Application by National Highways for an Order granting Development Consent to authorise the widening of an approximately 20.6km stretch of the existing A1 from Morpeth to Ellingham, with approximately 14.5km of online widening and approximately 6.1km of new offline highway

Thank you for consulting with Northumberland Wildlife Trust (NWT). Apologies for my short response and lack of knowledge of previous documents, as I have just received this consultation due to staff changes. Whilst NWT do not object to the proposals, and understand that a vast amount of work has already gone into or is proposed for the application, we have some concerns with the details of mitigation offered and whether a detailed LEMP will be provided. In addition to our previous correspondence, we have the following comments on the documents provided in the link:

**Appendix F - Proposed Woodland and Marginal  
Planting Plan (Part A and B)**

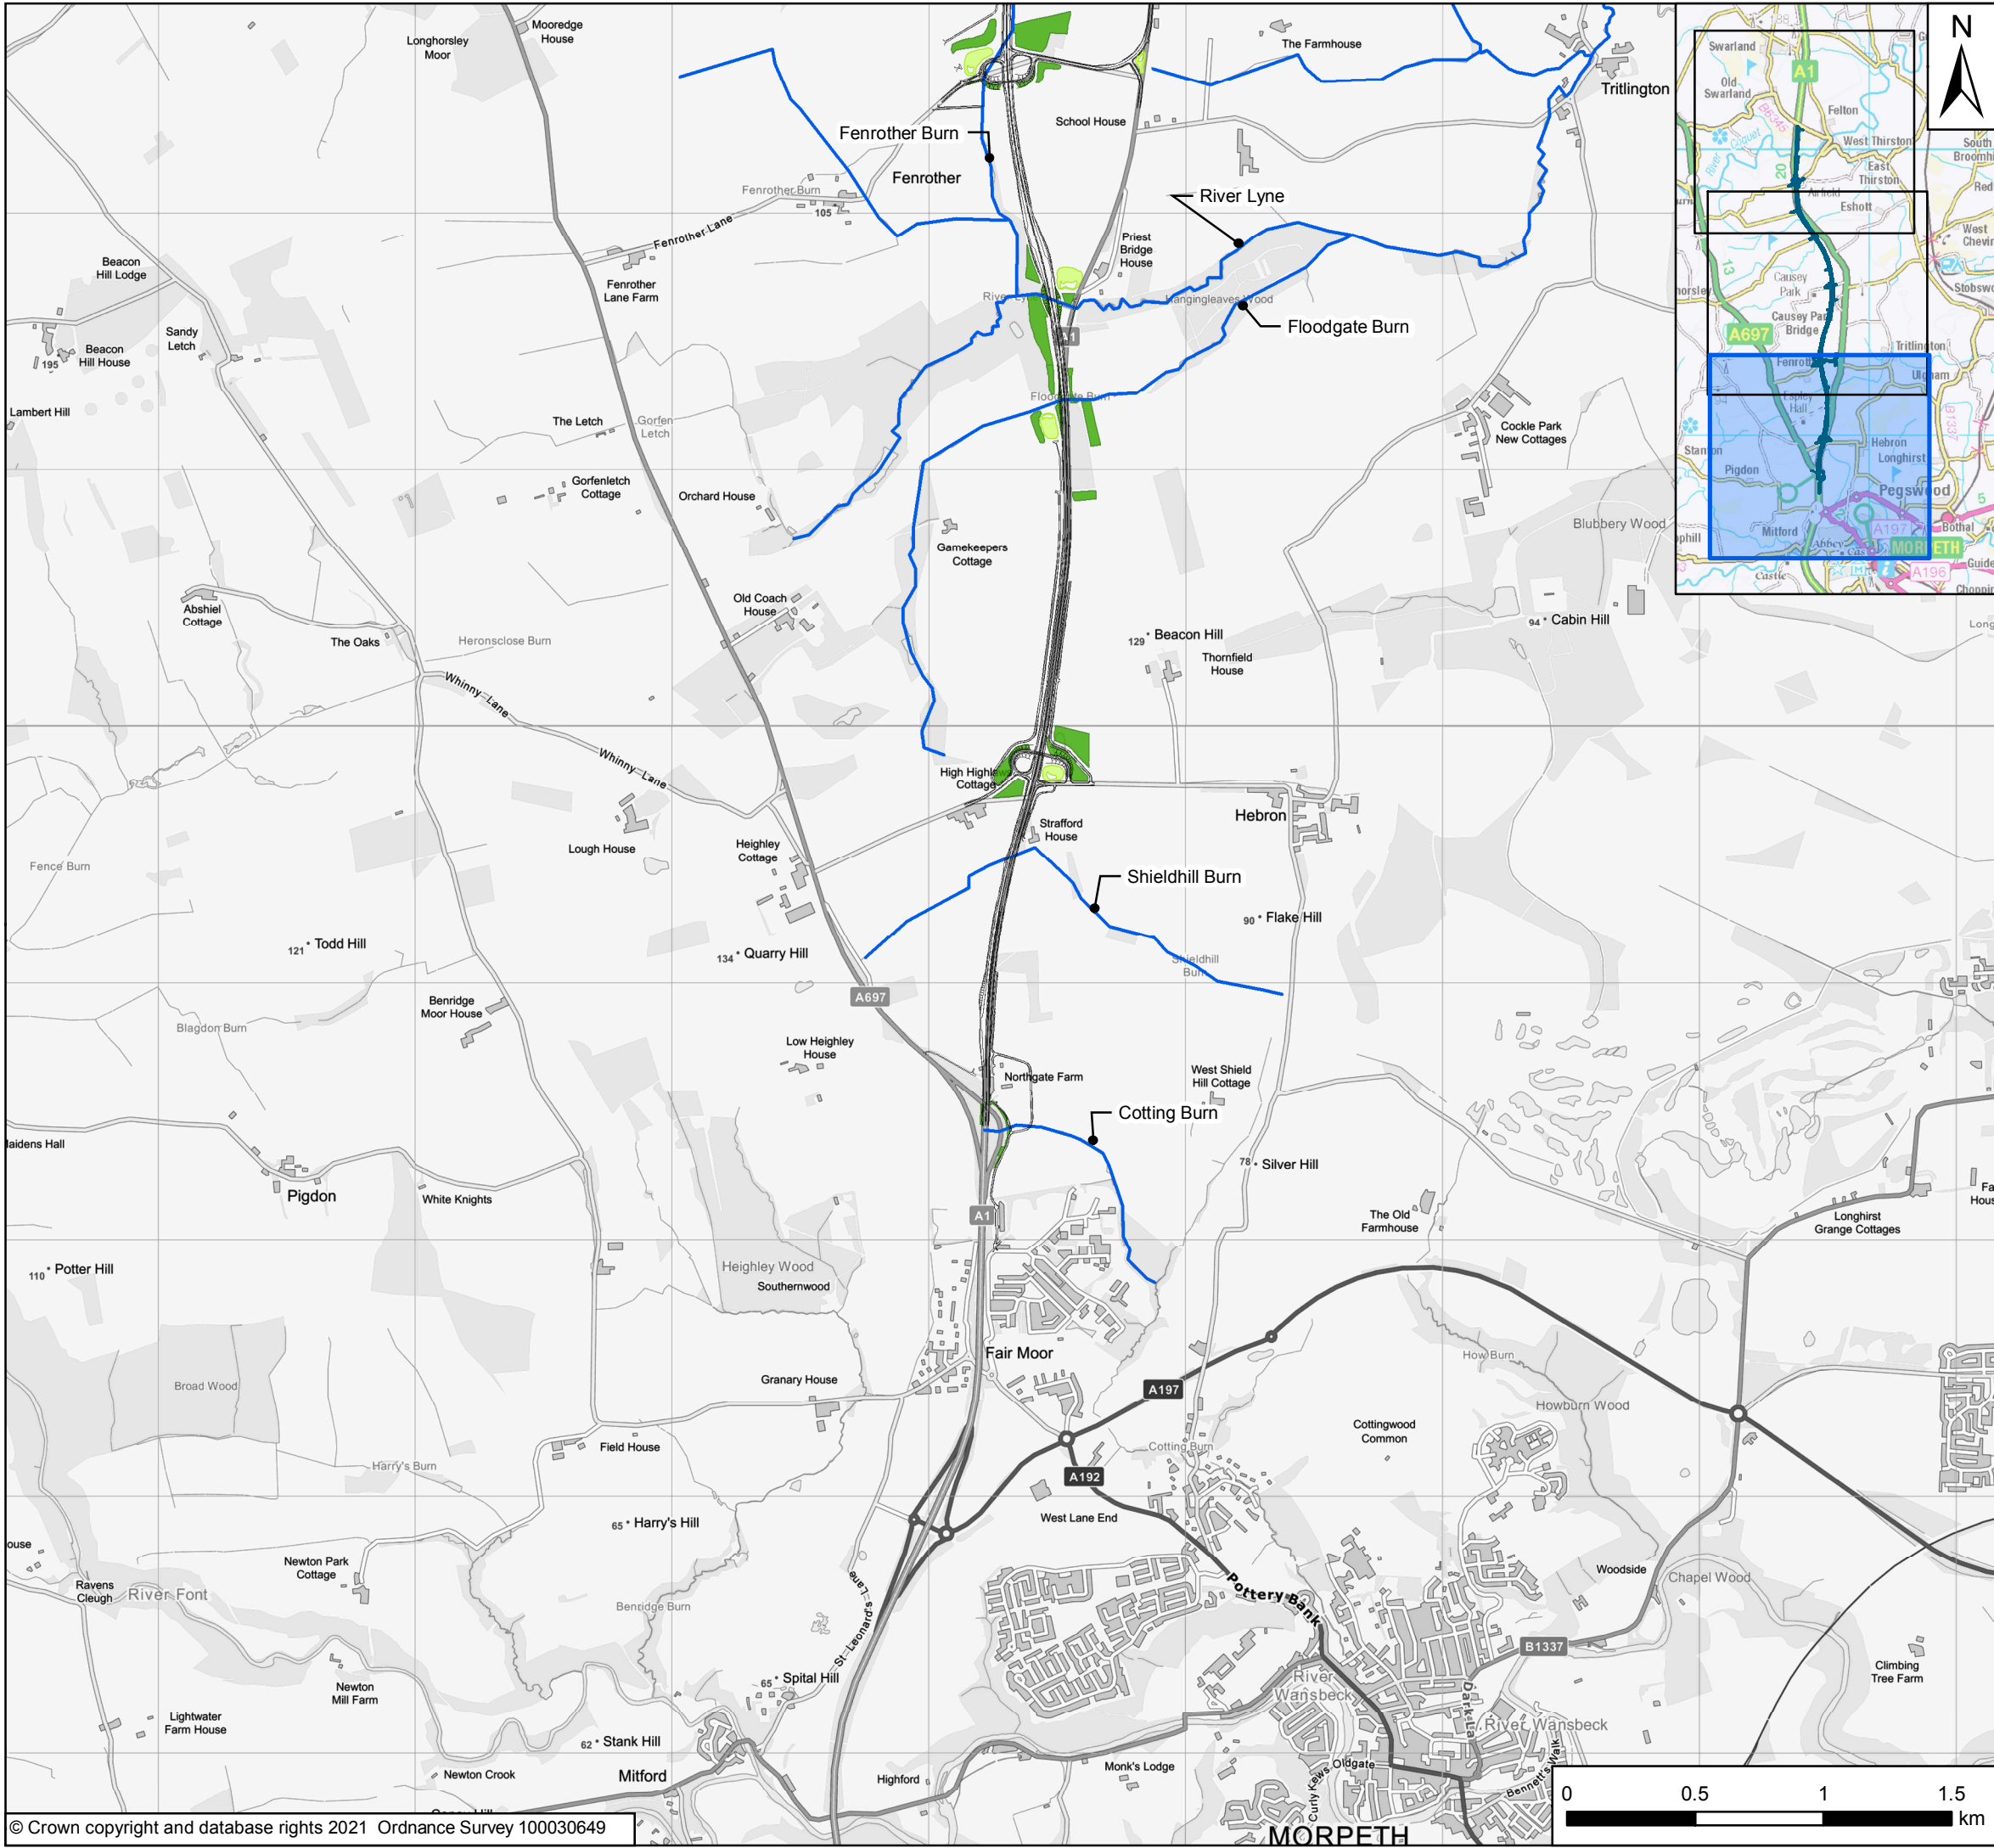
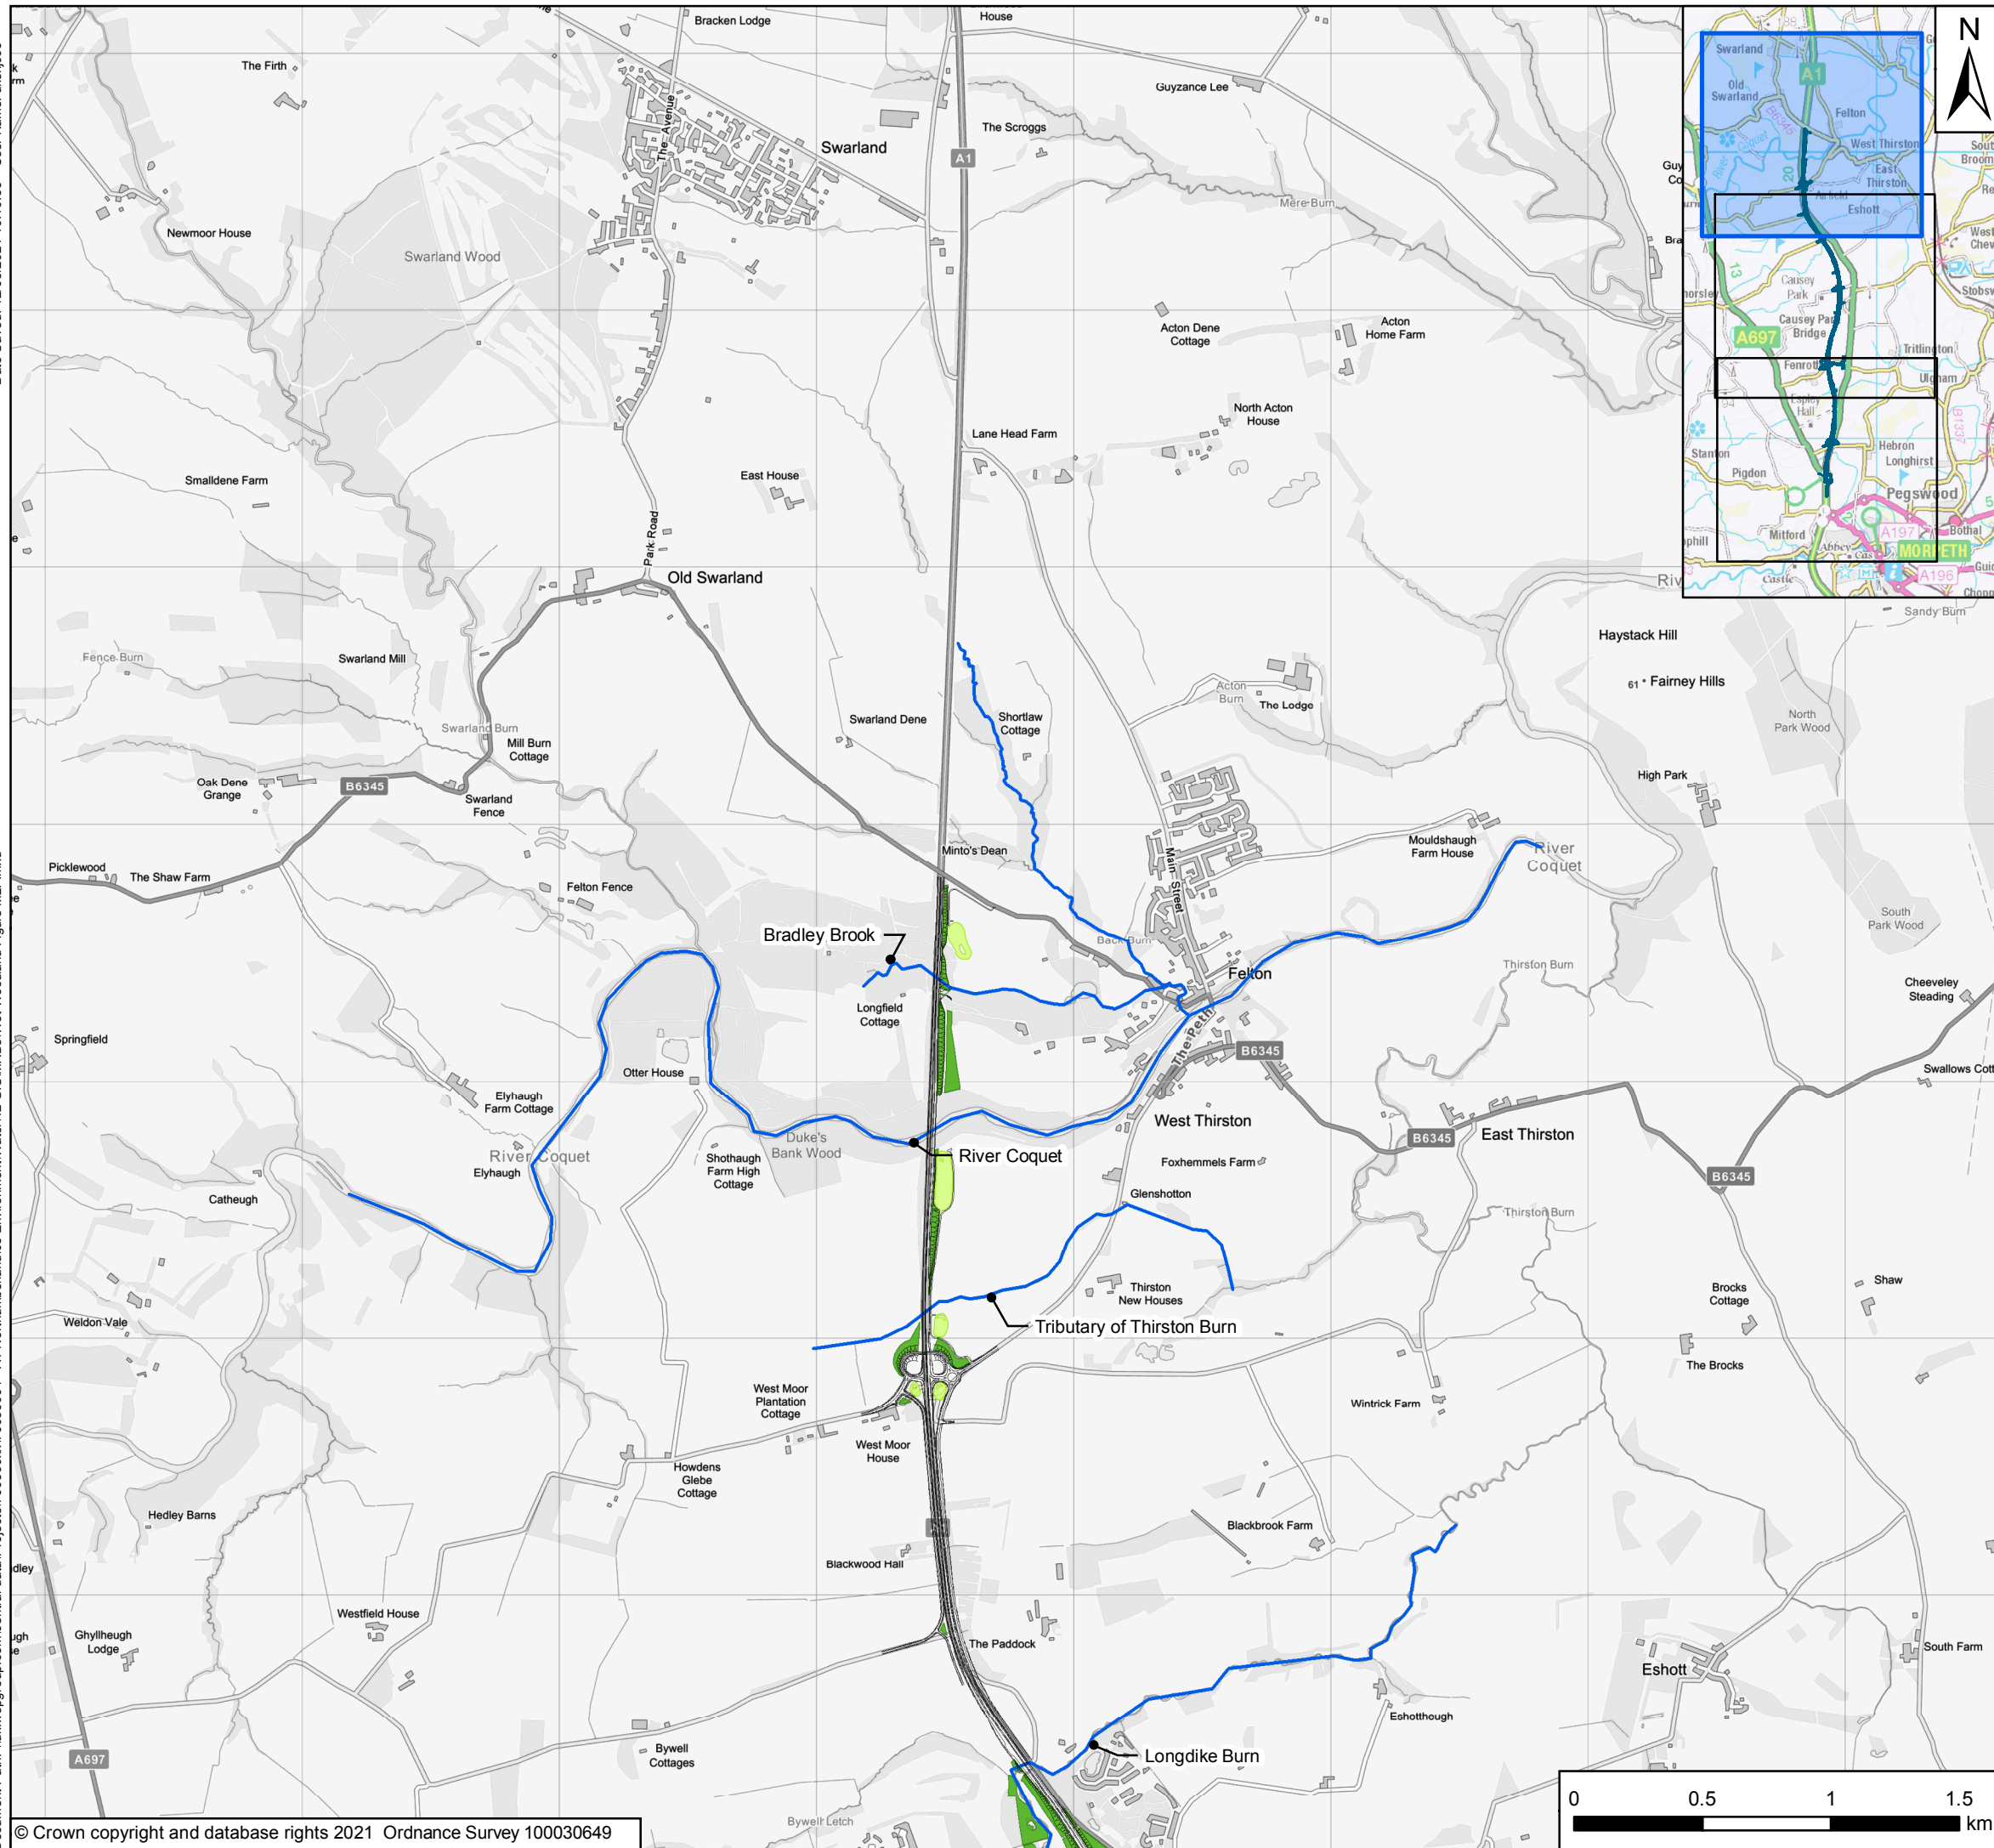
NWT would always request that all species used in the landscaping (for all habitats) be appropriate locally native species, not just UK native, and that hedgerows are species rich with 8 or more species. The ancient woodland species mix proposed on the landscaping plan (available through the link) includes horse chestnut, which is **not** native and beech which is not locally native and introduced to Northumberland. We would request that these two species be removed, if not already and a more appropriate species be used. In the indicative woodland block planting mix, beech and large-leaved lime are listed. Again, these species are not locally native and we would request that these species be removed from the list. While beech is a UK native, it will out compete and shade out locally native species, while the heavy and persistent leaf litter will smother groundflora and greatly reduce natural regeneration and biodiversity. Considering the amount of work that has gone into the proposals, this is a minor alteration and by including more appropriate species there should be positive impacts rather than negative impacts.
